An
Bord
Pleanála

Inspector's Report ABP-320259-24

Whether the piping and filling in of an open stream is or is not development and is or is not exempt development

Grangebeg, Dunlavin, Co. Kildare

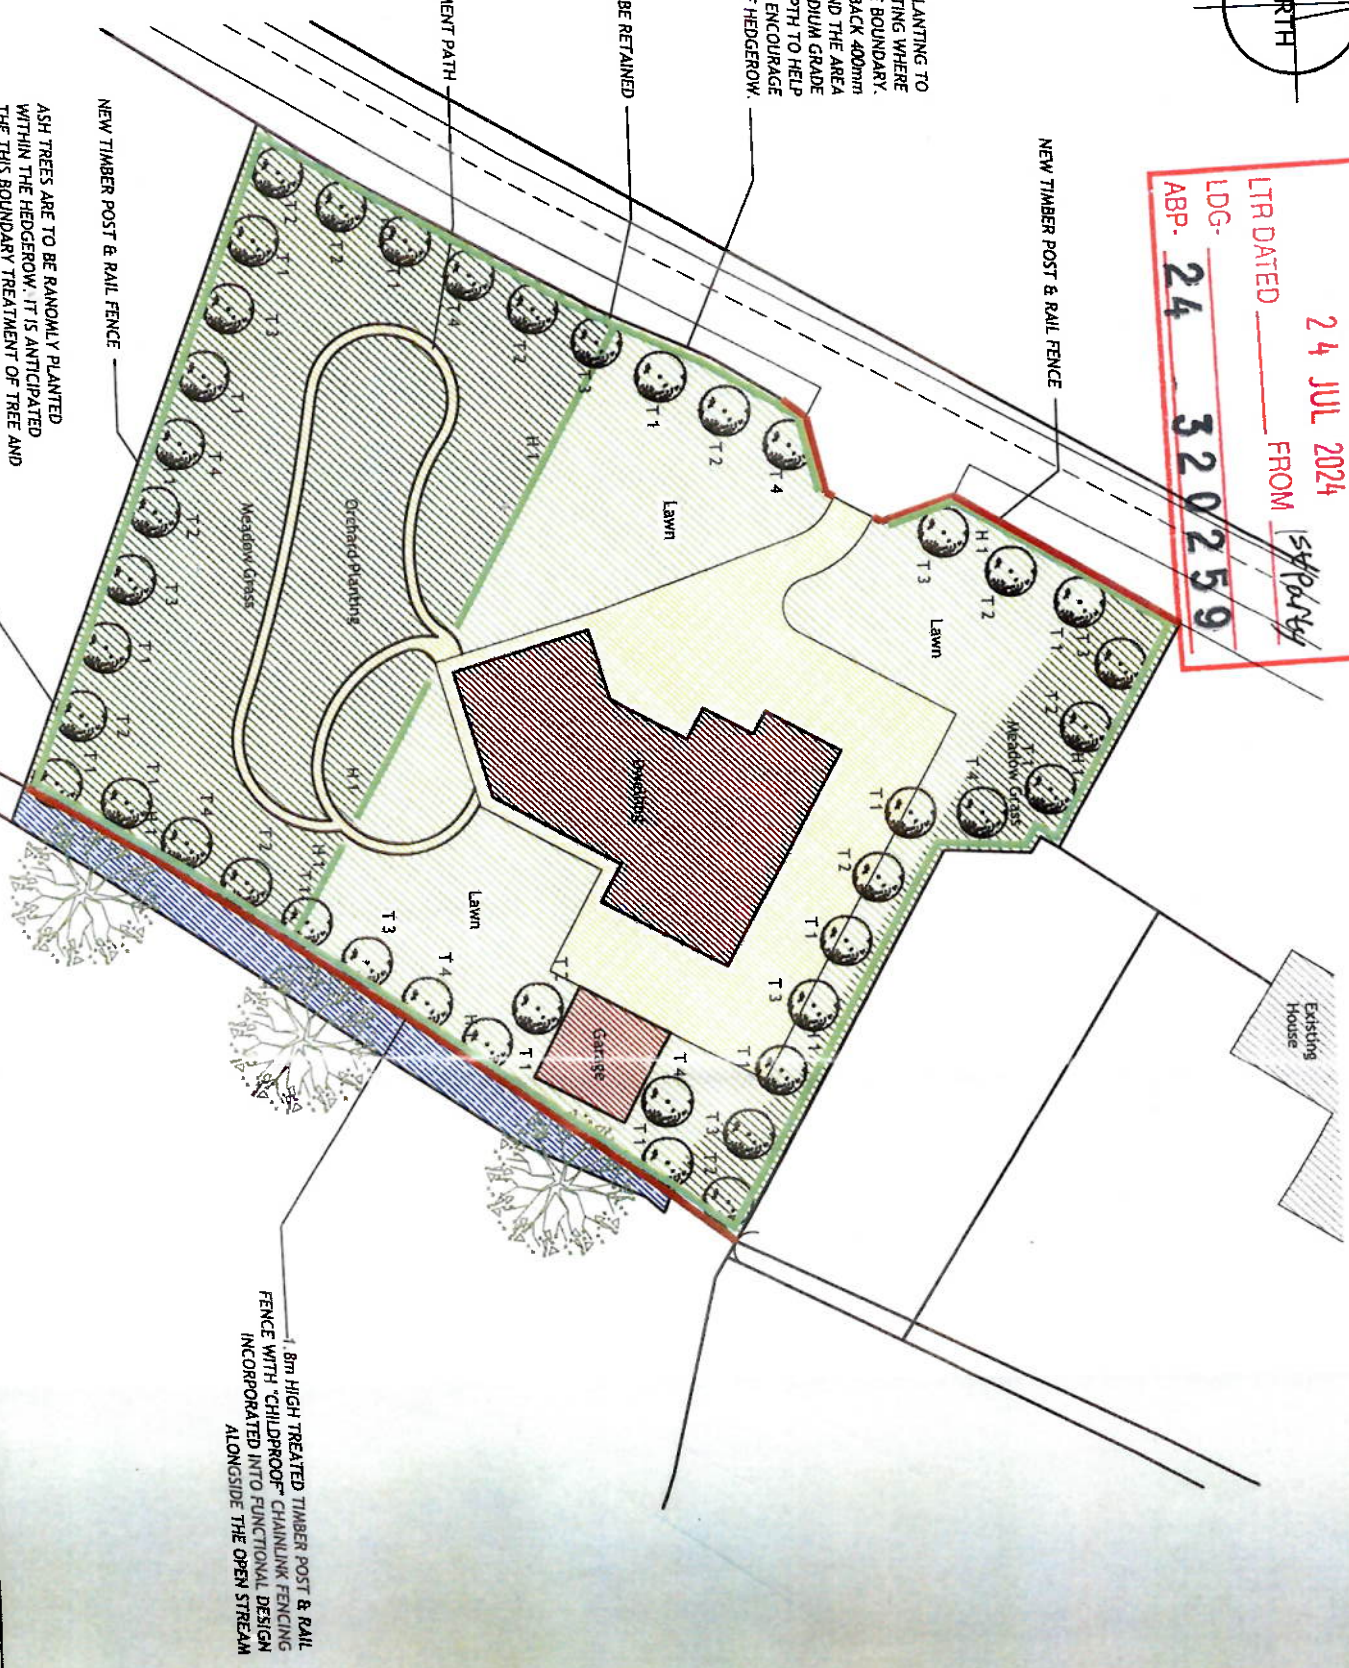
- Landscape drawing no. DR-178 was submitted in compliance with condition no. 5 clearly shows the stream as open and is referenced in the notes – “1.8m high treated timber post and rail fence with ‘childproof’ chain link fencing incorporated into functional design alongside open stream’. On foot of this submission the Planning Authority confirmed that condition no.s 4 and 5 were complied with. This means the Planning Authority agreed to the stream remaining open.
- The piping and filling of the stream is in direct contravention of the agreement reached between the developer and the Planning Authority under the conditions. This means the exemption provide for under article 6 cannot be applied and the development cannot be declared exempted development.
- The serious implications of ignoring the FRA must be considered.

- 8.3.4. In the current referral, the referrer Thomas Moore states that the subject watercourse is within the red line site boundary of the landowner Andrea Moore’s site, which was subject to a Board appeal PL09.248060. Mr Moore states that this application refers to an open watercourse in the drawings, landscape plan and FRA and therefore any deviation from those documents represents a breach of condition no. 1. Mr Moore also submits that as the compliance drawing for condition no. 5 referred to an open watercourse, then that condition is also breached.

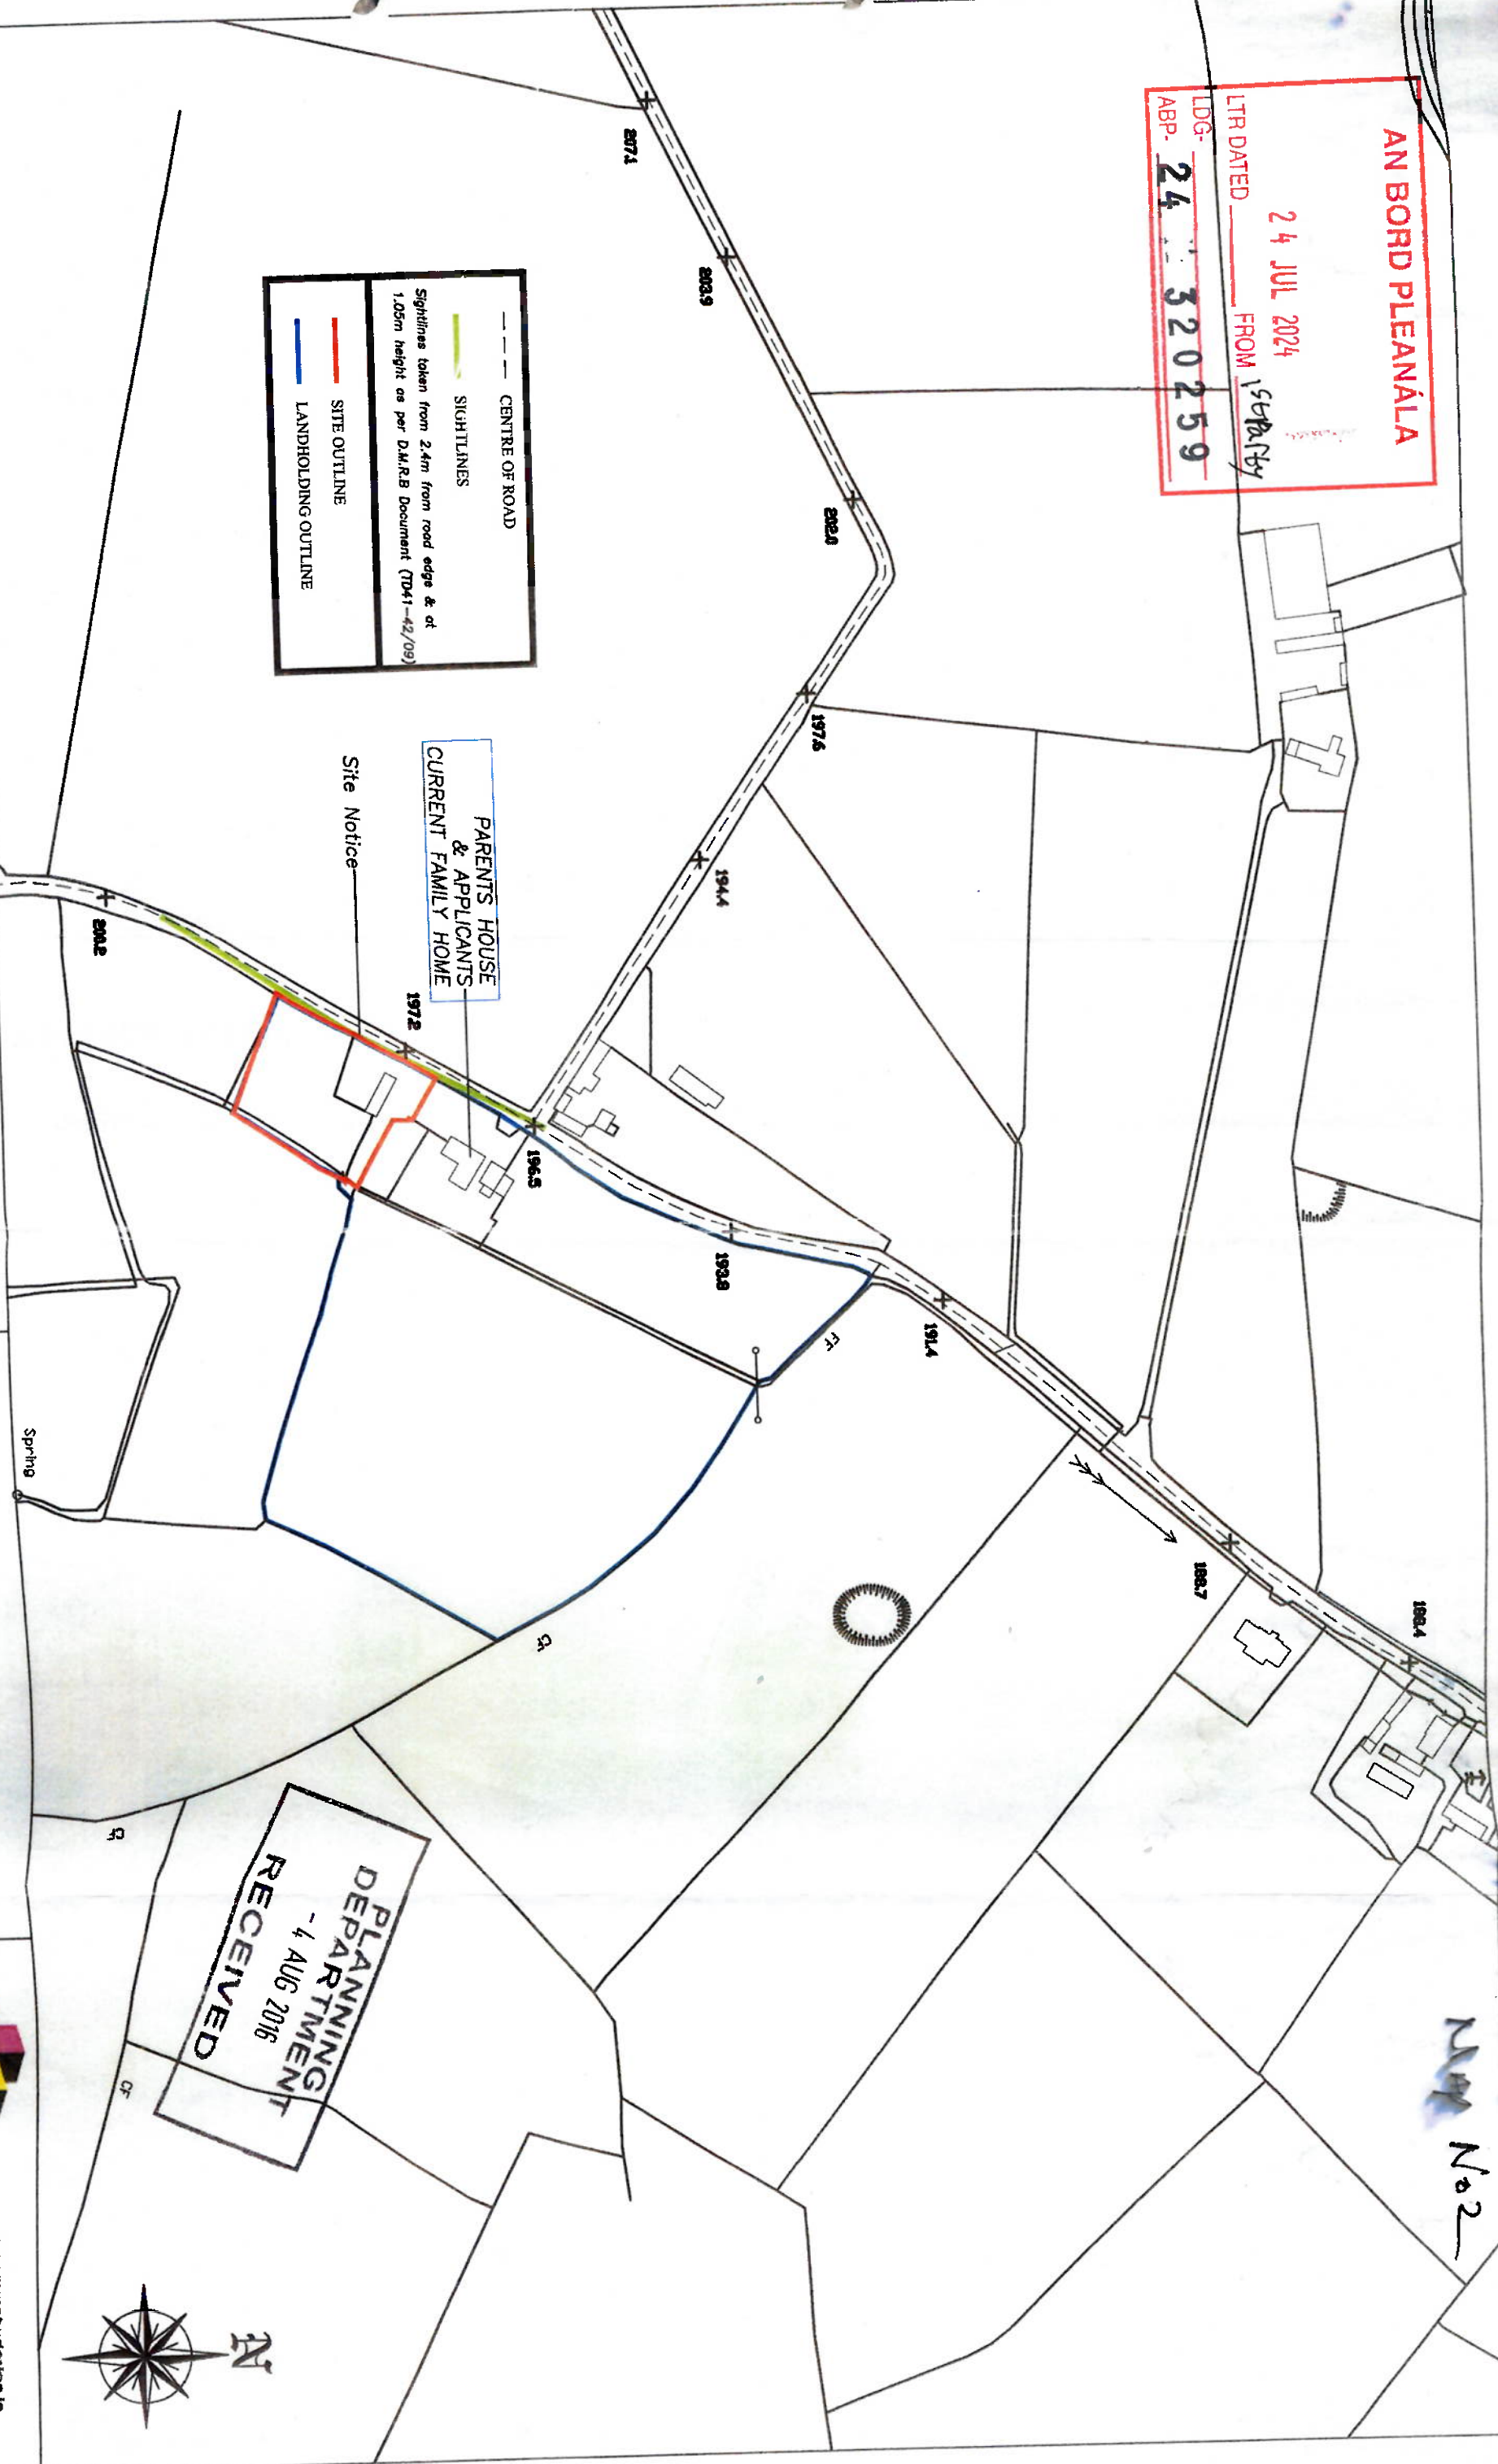
- 8.3.5. Mr Moore included a copy of drawing no. 4111-02 with his referral request. This drawing was submitted to Kildare County Council in January 2017 as part of a Further Information response within application ref. 16/823 (subsequently appealed to the Board under PL09.248060) which shows a straight blue line within the site boundaries. This feature is not labelled but occurs within the approximate location of the watercourse.
